Application No: AL/83/21/PL
Site Address: Land adj to 1 Hook Lane Westergate PO20 3QL
Description of works: Demolition of existing storage building & garage, replace with 1 No. 3 bed dwelling, including new access to existing dwelling. This application is in CIL Zone 2 and is CIL liable as new dwelling.

Thank you for your internet representation made on 13th August 2021 which has been recorded as an objection with the comments as follows:

PROPOSED GROUND FLOOR
PLAN scale 1:100

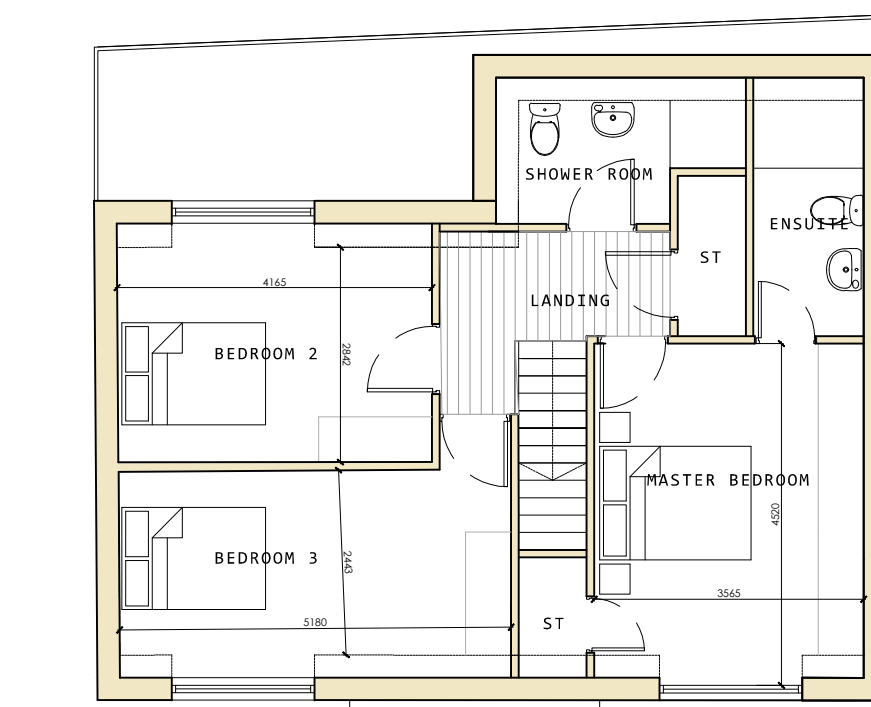
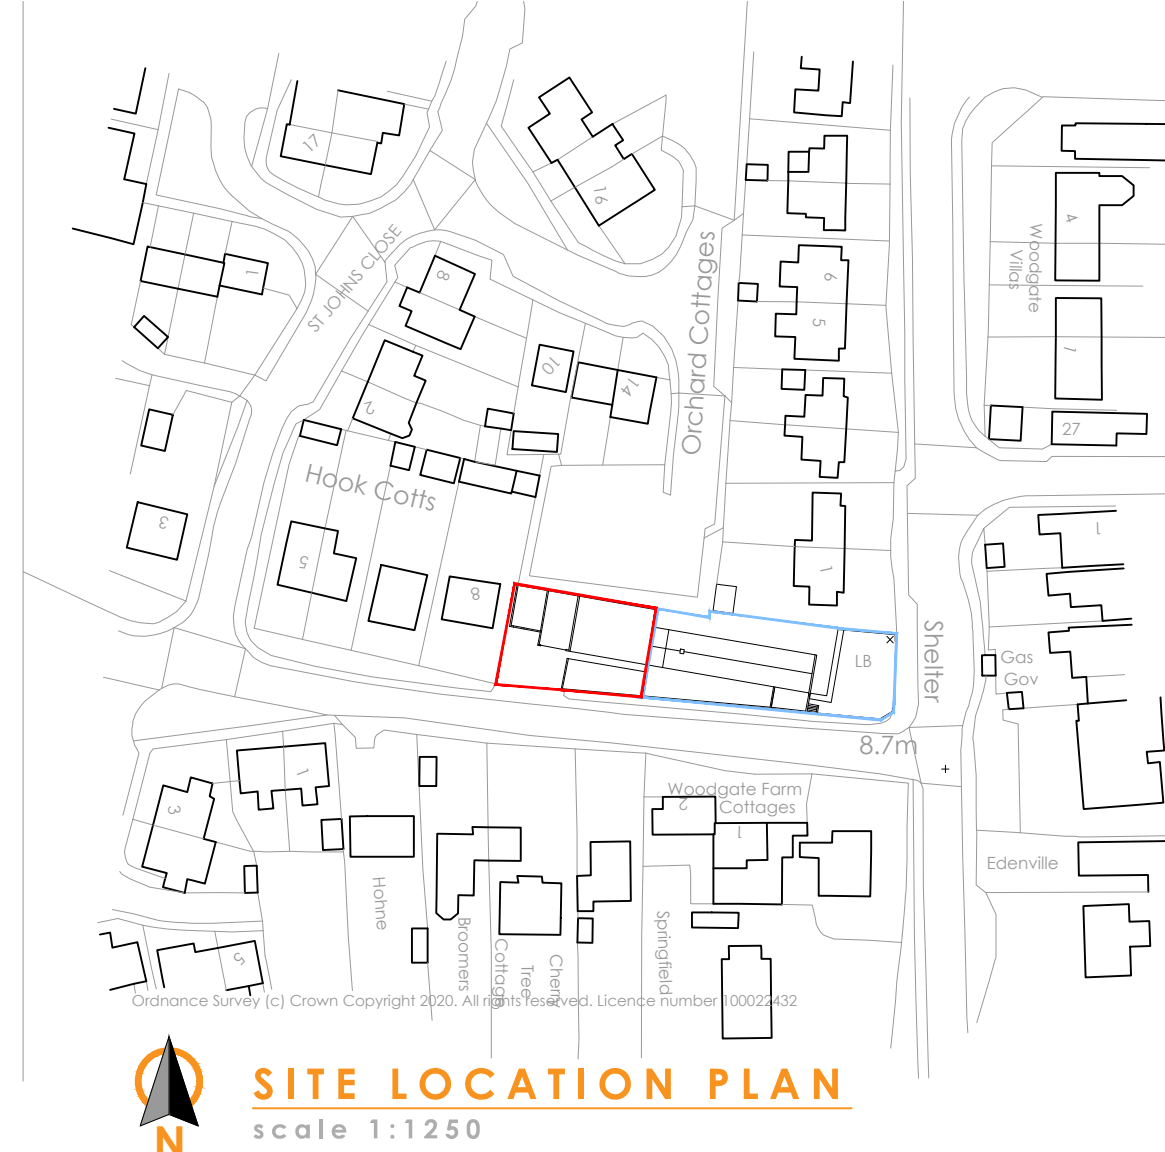
The parking allocated for this development is not sufficient for a 3-bed dwelling, and this area of Hook Lane is particularly susceptible to parked cars on the Highway blocking the junction with Westergate Street. This contravenes the ANDP policy GA3.1 and 3.2, and the Arun Policy T SP1, parking standards.
